**Subject: Belmont Desalination Plant SSI - 8896  
(Council Ref: MISC/279/2017/B)**

Thank you for the opportunity to comment on the proposed Belmont Drought Response Desalination Plant at 12A Ocean Park Road, Belmont,

TITLE: CS0865 TEMPORARY DESALINATION PLANT CONCEPT DESIGN SITE LAYOUT			SIZE: A1	SCALE: 1:750	INDEX No. -	DRAWING No. 15830	SHEET 010	REV No. 0A
---	--	--	-------------	-----------------	----------------	----------------------	--------------	---------------

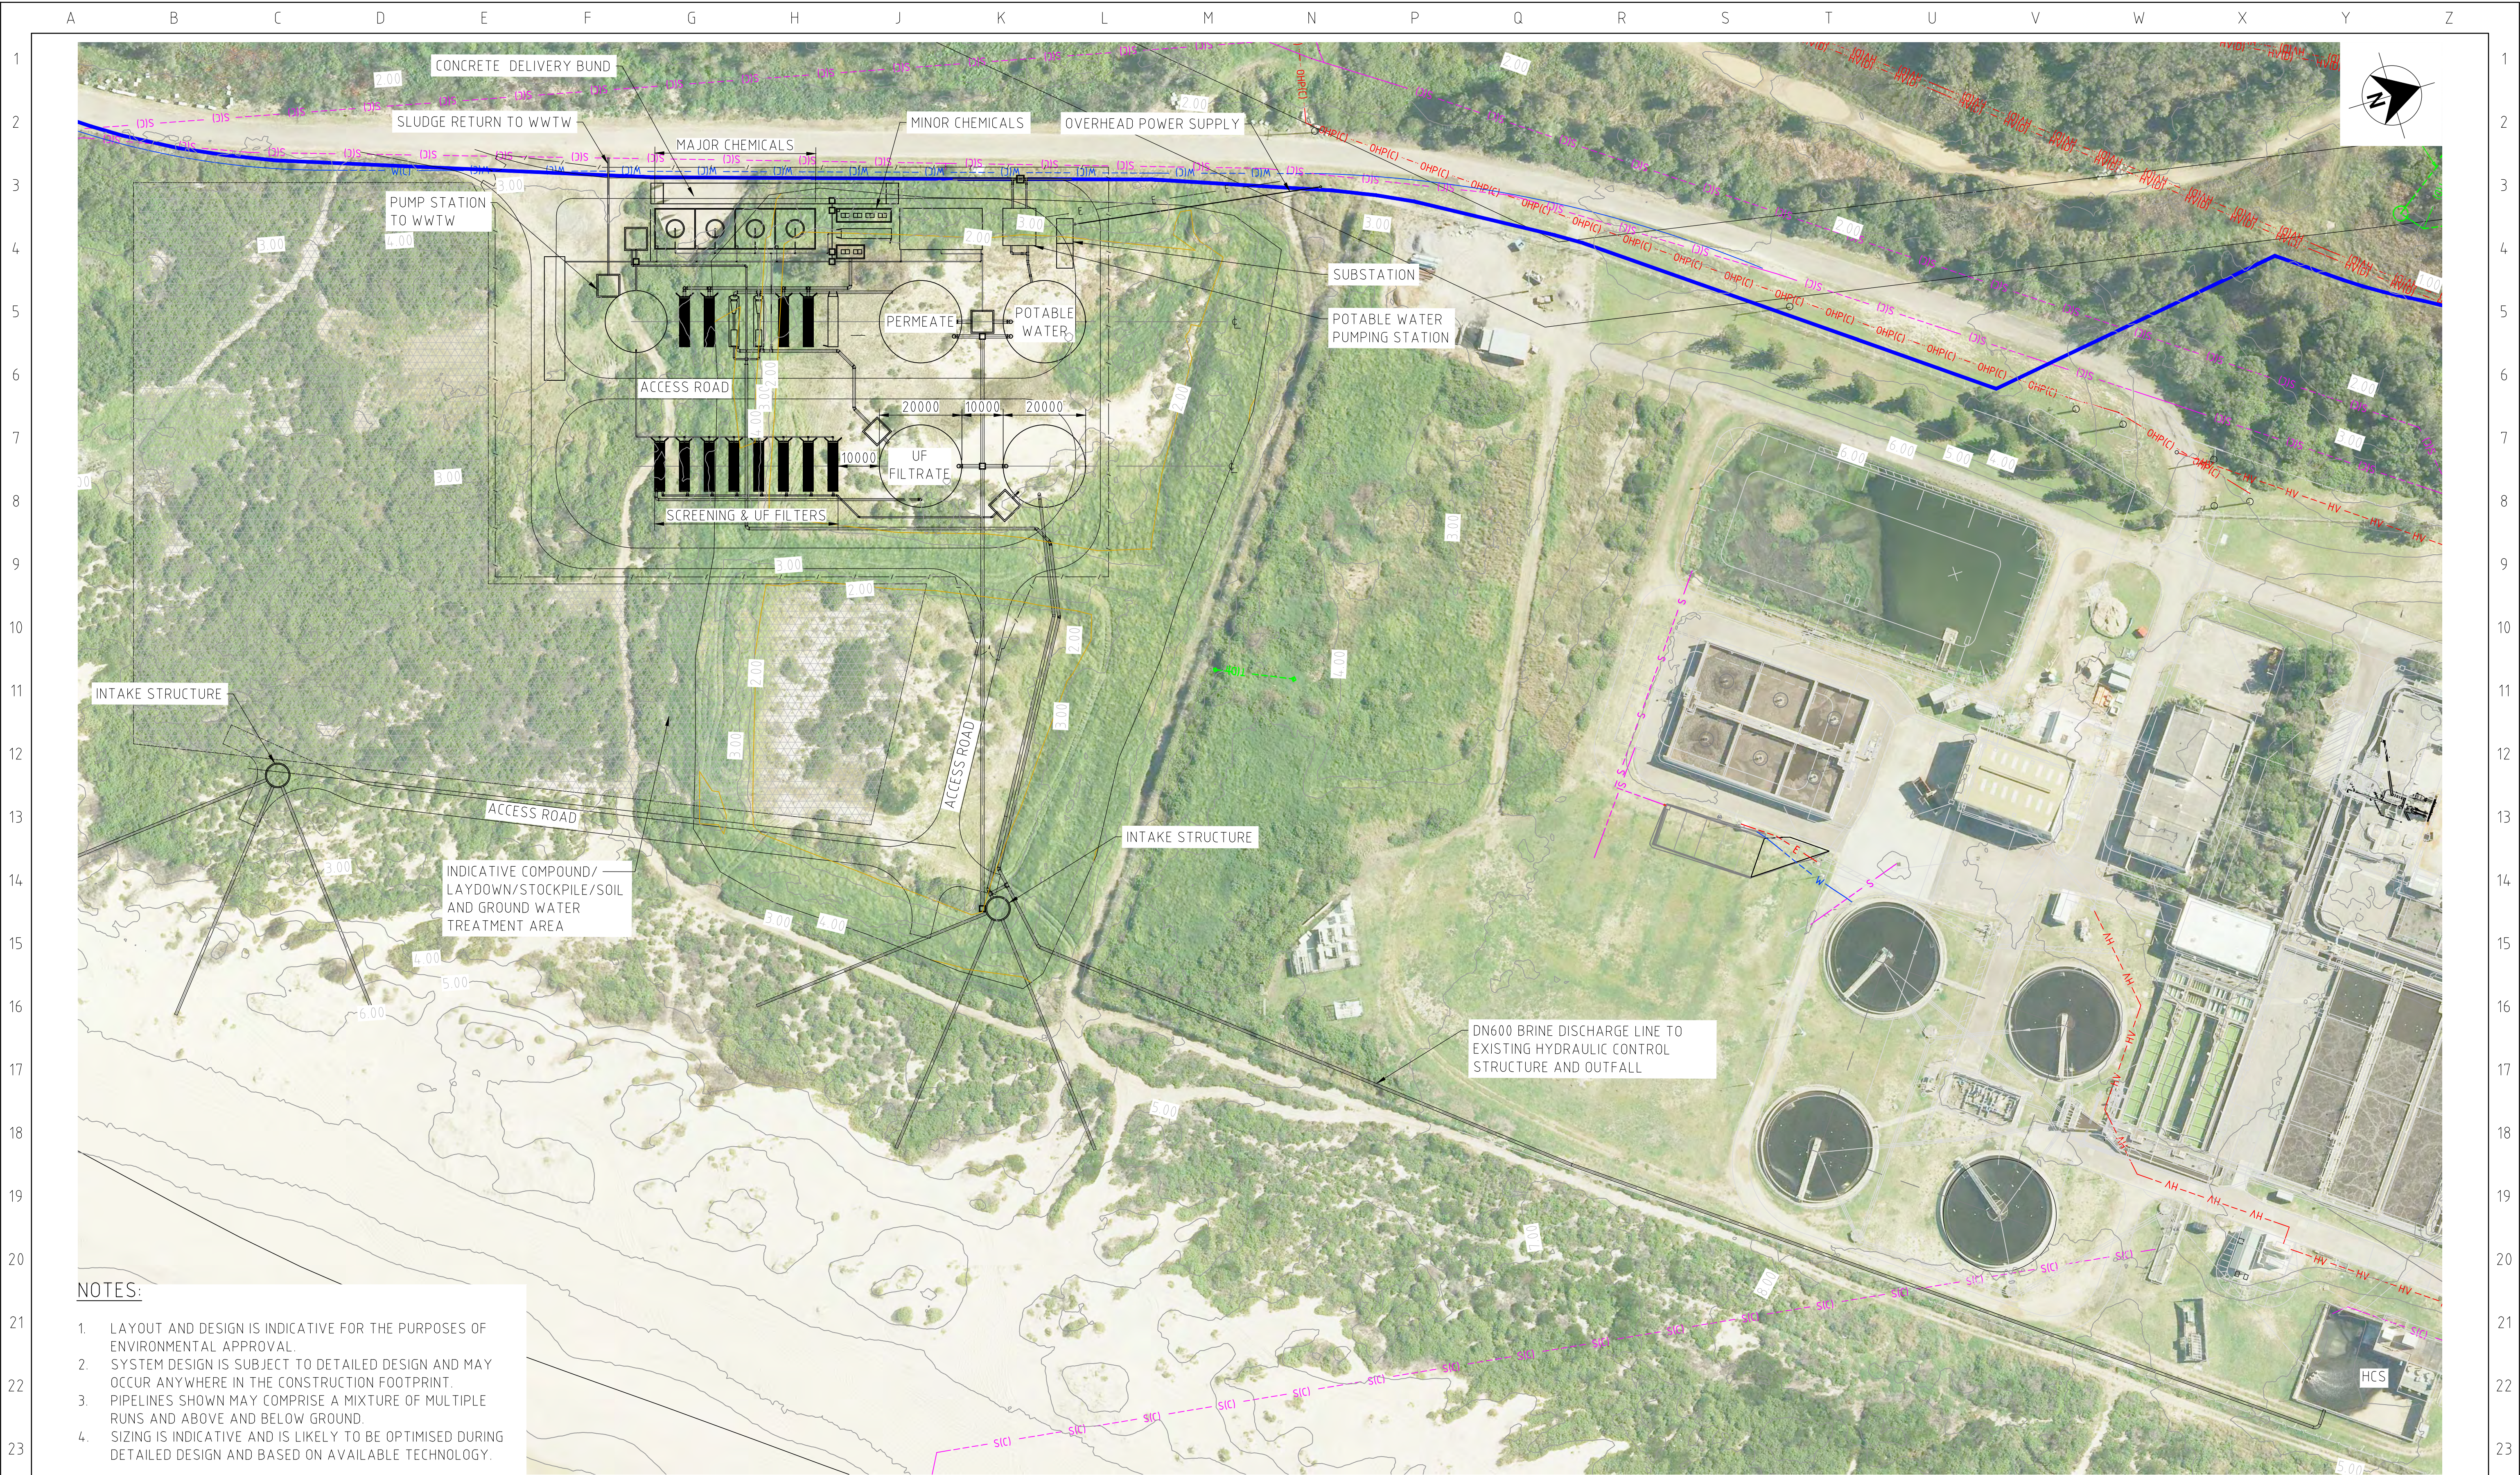
The proposed development has not achieved adequate facilities for service vehicles with regard to AS 2890.2 Parking Facilities – Off Street commercial vehicle facilities.

- a) It should be demonstrated where and how service vehicles are parked/unloaded on the site. It is considered the access road should not be used for this purpose.
